Subject: Rezoning Petition Review

Rezoning Petition #: 22-114

Location of Property: Approximately 4.18 acres located on the northeast side of Ridge Rd, south of Mallard Creek Rd and north of I-85.

REZONING PLAN

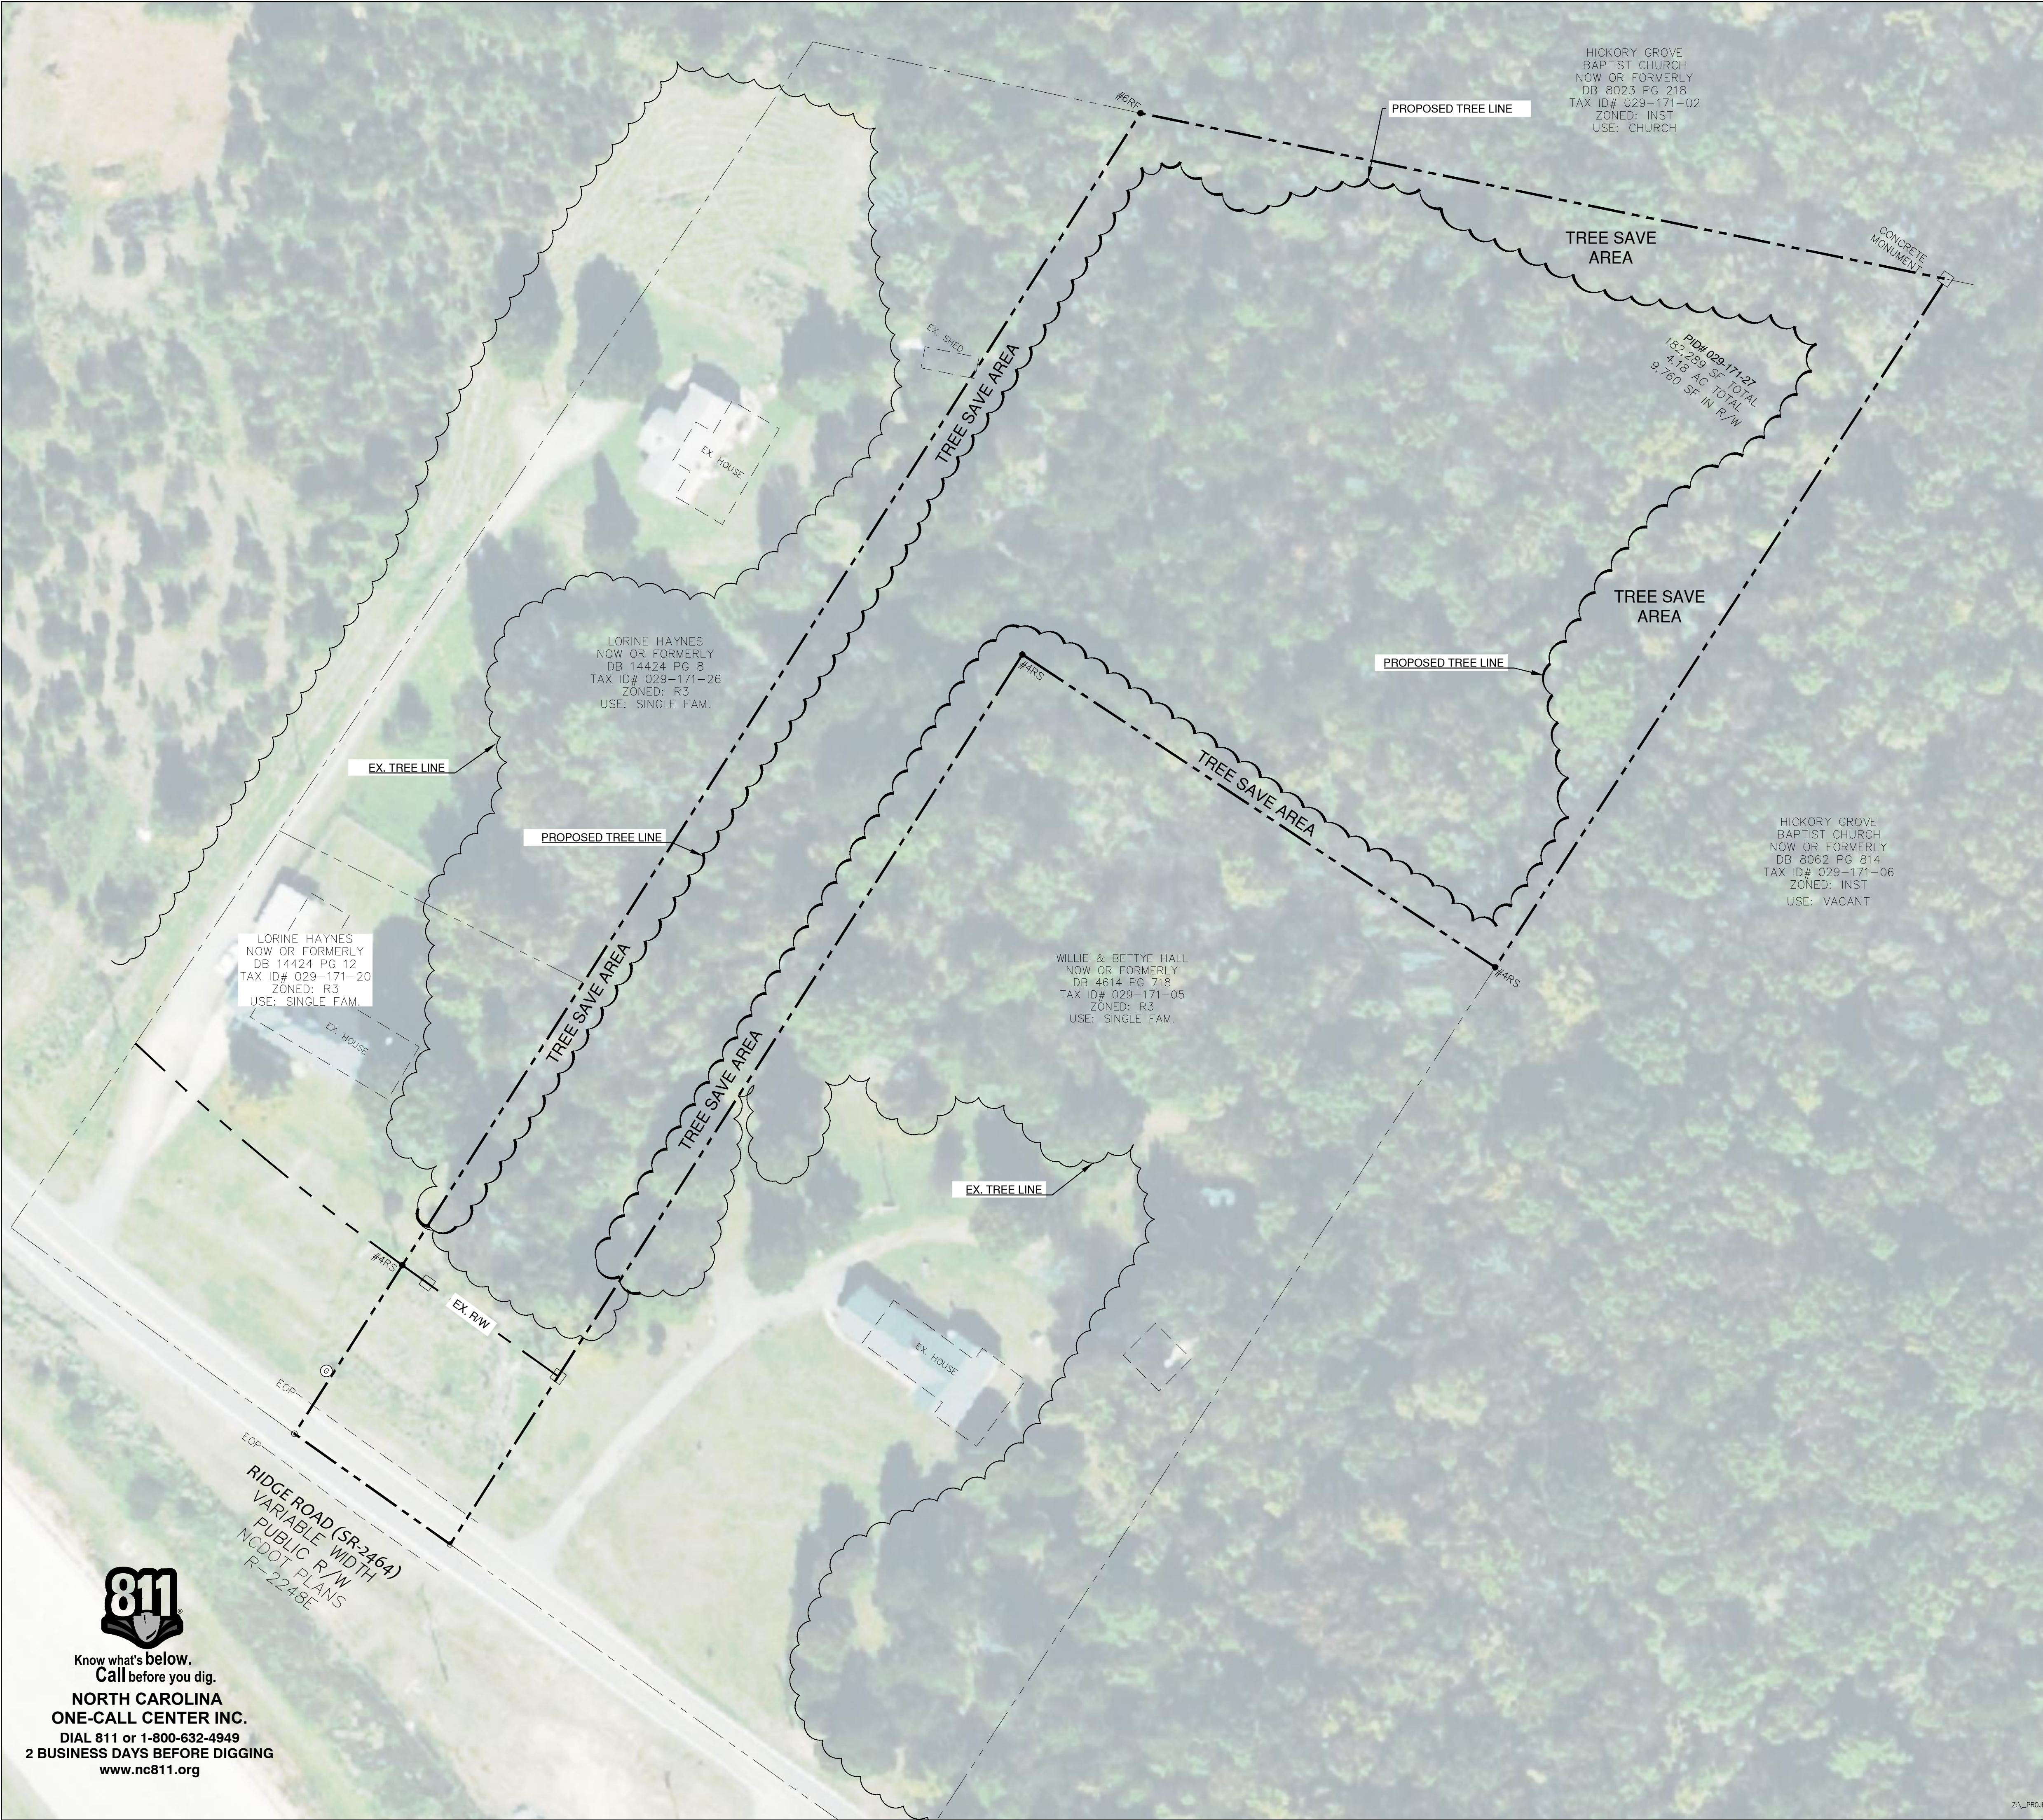
The proposed rezoning plan sheet indicates a proposed location for storm water management. Please include the following notes on the plan sheet under "Environmental Features": *The location, size, and type of storm water management systems depicted on the Rezoning Plan are subject to review and approval as part of the full development plan submittal and are not implicitly approved with this rezoning. Adjustments may be necessary in order to accommodate actual storm water treatment requirements and natural site discharge points.*
